### Department of Transportation

December 14, 2021

RE: Ellicott Sand and Gravel Special Use - AL2014

The Traffic Impact Study for Ellicott Sand and Gravel dated October 12, 2021 and supporting documentation has been reviewed by a CDOT Traffic Engineer. Their comments follow:

Figure 3  
**Proposed Primary Haul Route**  
 Ellicott Sand + Gravel (LSC# 194980)

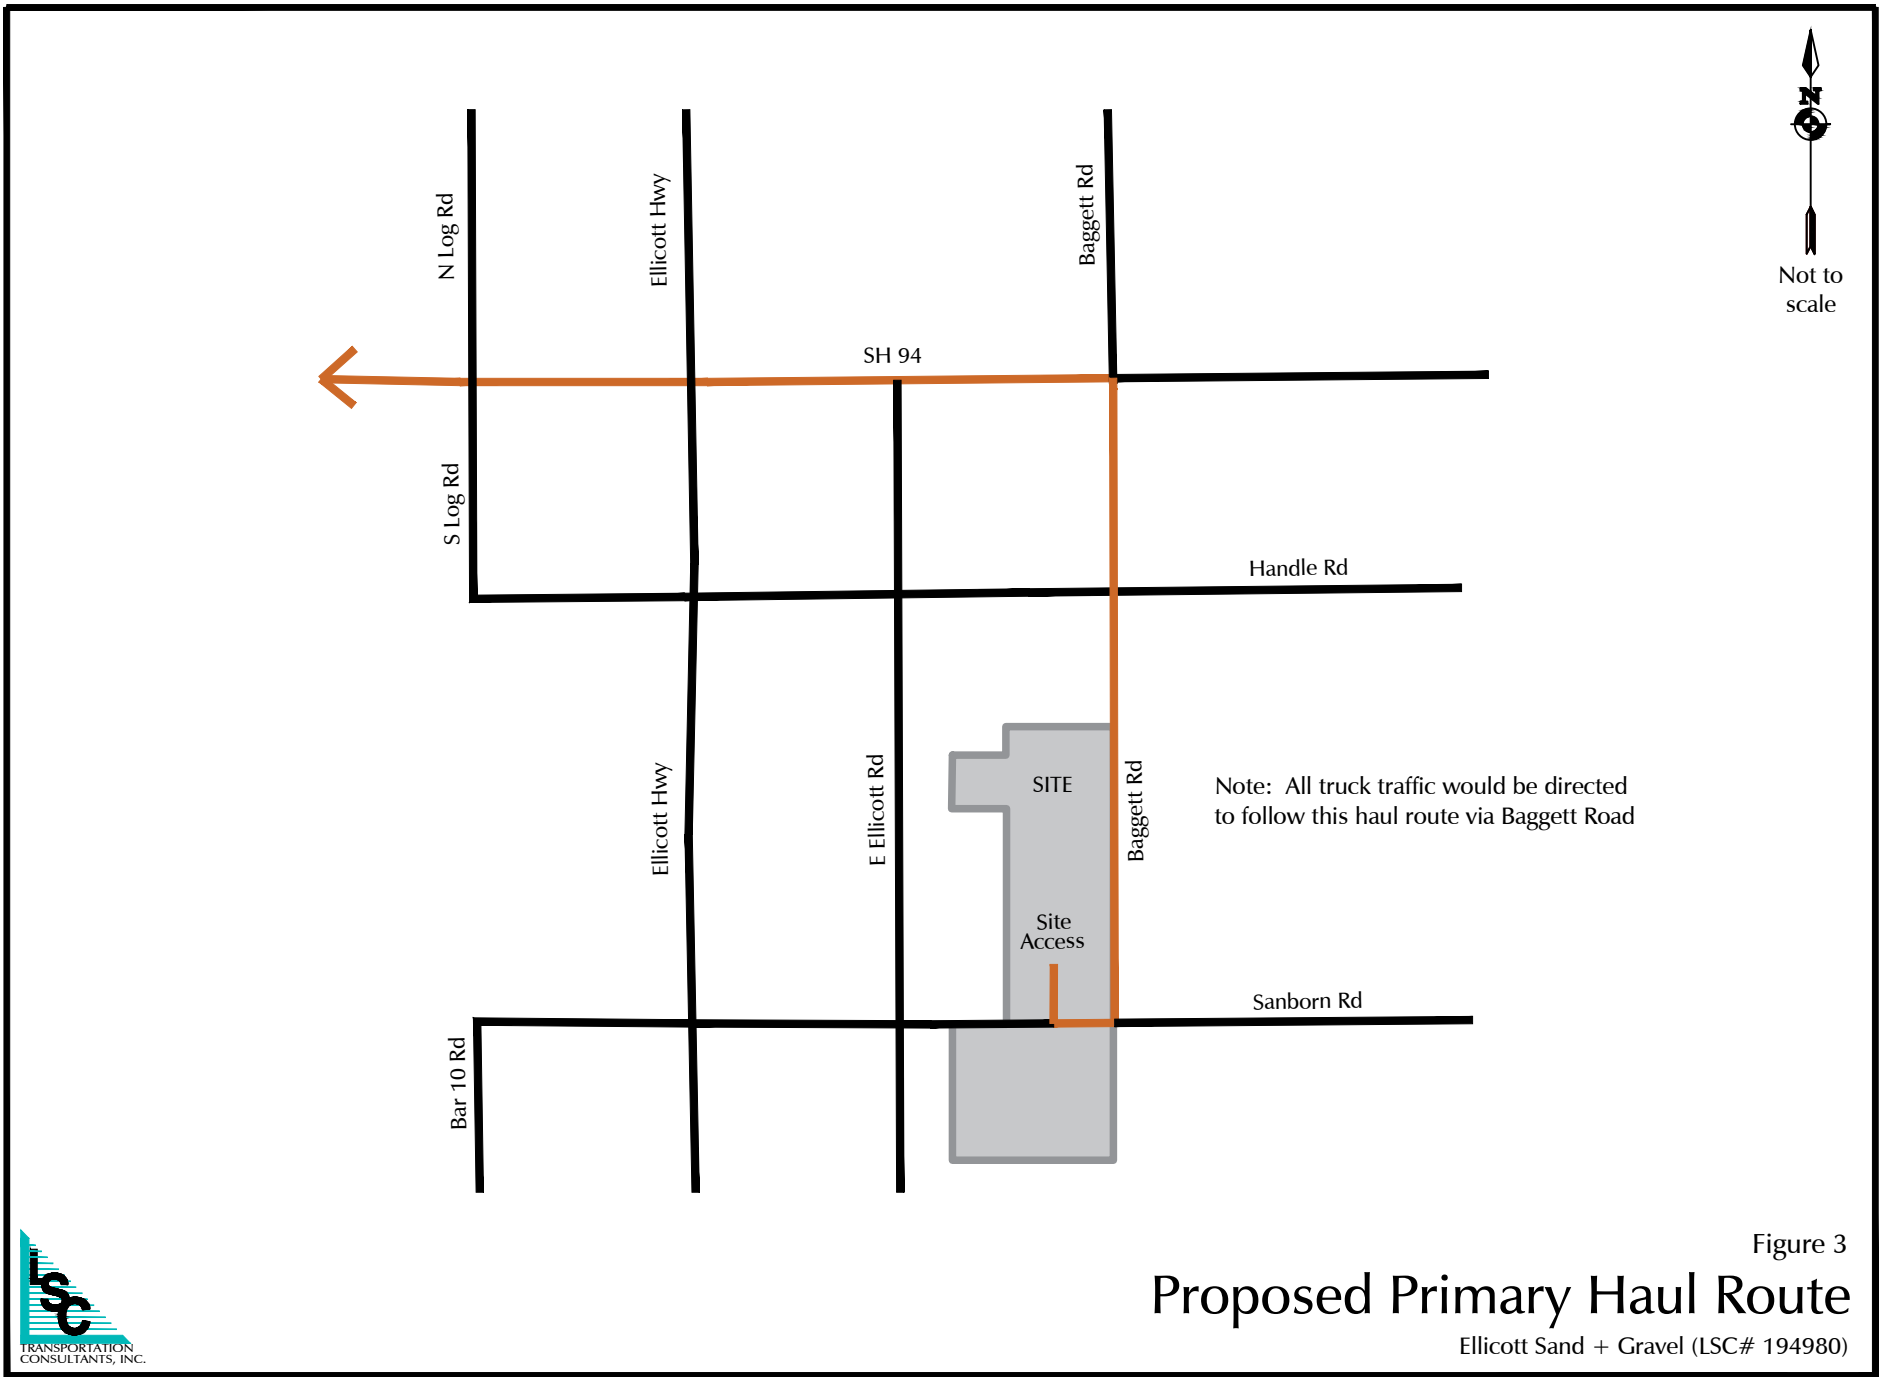
- A CDOT Access Permit will be required for this development. As part of the access permit the Applicant will be required the following improvements at SH94 & Baggett:
- The Permittee will be required to make improvements to the corner radii on the southwest and southwest corners to accommodate turning tractor trailers onto and off of Baggett and SH94. This work will include, but is not limited to, grading, paving of Baggett for a distance of 50' minimum or the furthest right-of-way line south of SH94, relocation of signage as necessary, and any other improvements as determined by the Engineer. The radii shall be designed per Section 4.6 of the State Highway Access Code.
- The current response letter to CDOT does not indicate acknowledgement of the comments dated June 24, 2021 above. Letter should be revised to reflect comments.

- Section 2.6(3) of the State Highway Access Code, states that if the proposed vehicle volumes increase by 20 percent or more or property improvements are occurring an updated access permit will be required for the intersection of SH94 and Baggett Rd according to the haul route.
- A State Highway Application has not been made with CDOT to date.
- Please contact Arthur Gonzales with CDOT for Access Permitting Processes. Contact information is below.
